Your Ref: AL/64/18/DOC

01 October 2018

Town & Country Planning Act 1990 (as amended)
Town and Country Planning (Development Management Procedure) (England) Order 2015
Application for approval of details reserved by conditions imposed under planning permission
AL/75/14/OUT relating to condition No.4 (Surface Water Drainage Details), 5 (Sewer Diversion
Details), 6 (Cycle parking), 7 (Parking Spaces) & 9 (Construction Management Plan)
Land to rear of Woodgate Farm Hook Lane, Aldingbourne,

Job title:	Development at rear of Woodgate Farm
Drawing title:	Proposed Soakaway Details
Drawing number:	17-(01) 104
Client:	Guilfoyle Construction Ltd
Revision:	P2
Date of revision:	10.07.2018
Revision detail:	minor revision to included recessed cover & other changes.
Status:	PRELIMINARY

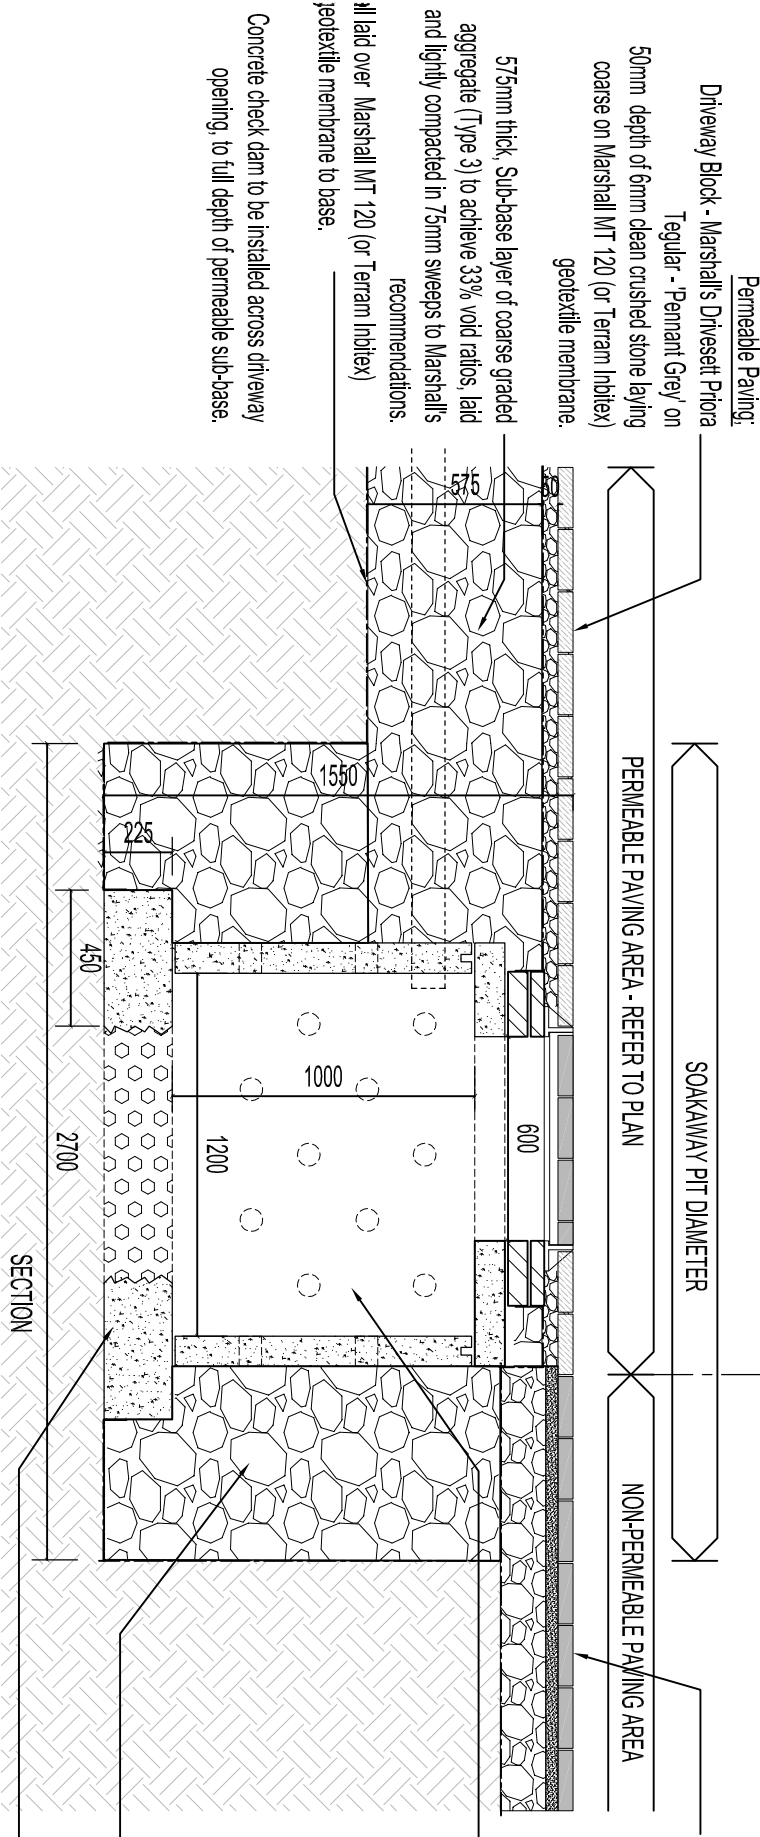
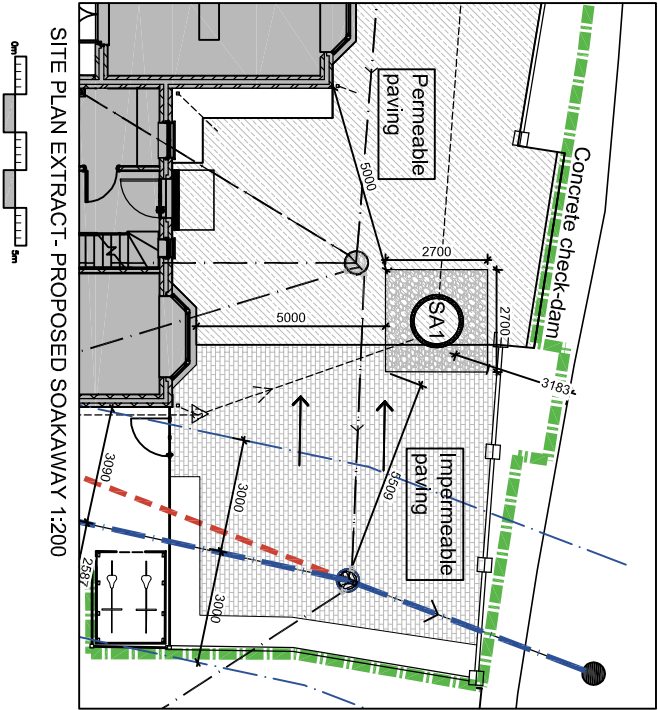
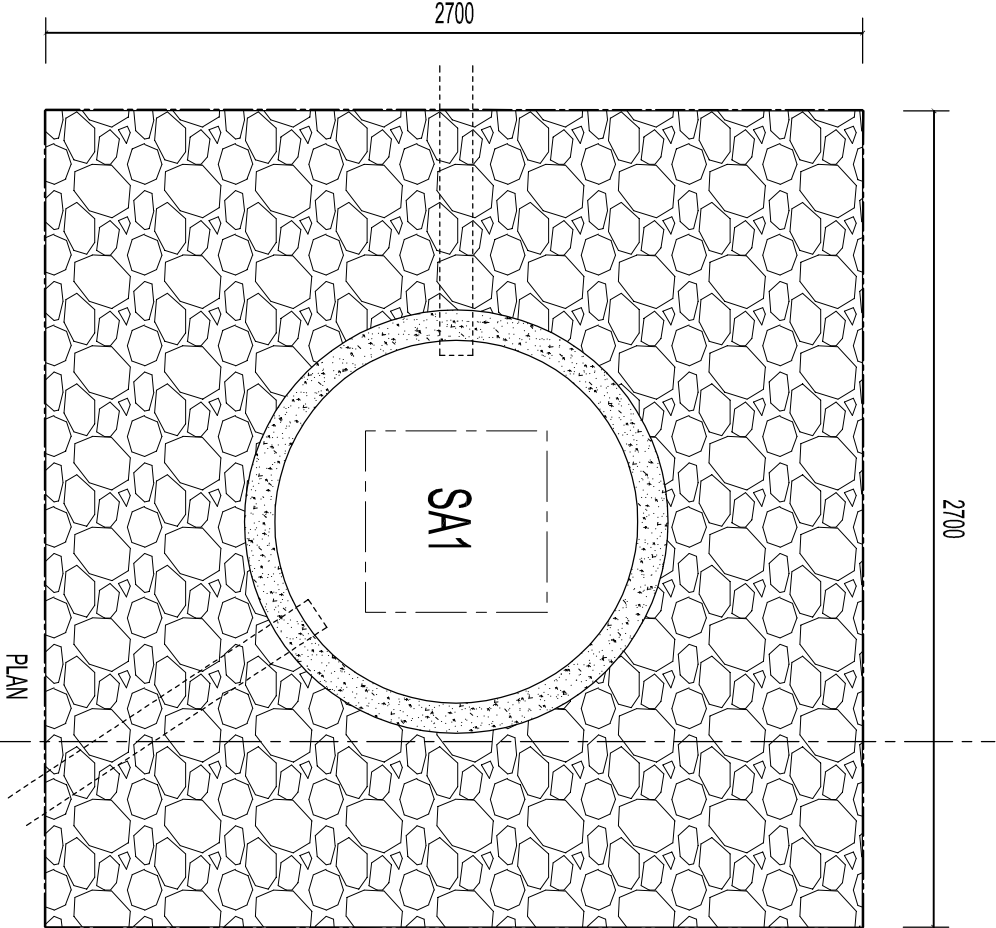
"No winter groundwater testing or infiltration test results have been submitted. Please supply this information so that the proposals can be reviewed."

We wrote to you on 07 August 2018 to make you aware of this issue but to date no further details have been provided. As such, the condition cannot be discharged and you will need to

make a revised submission.
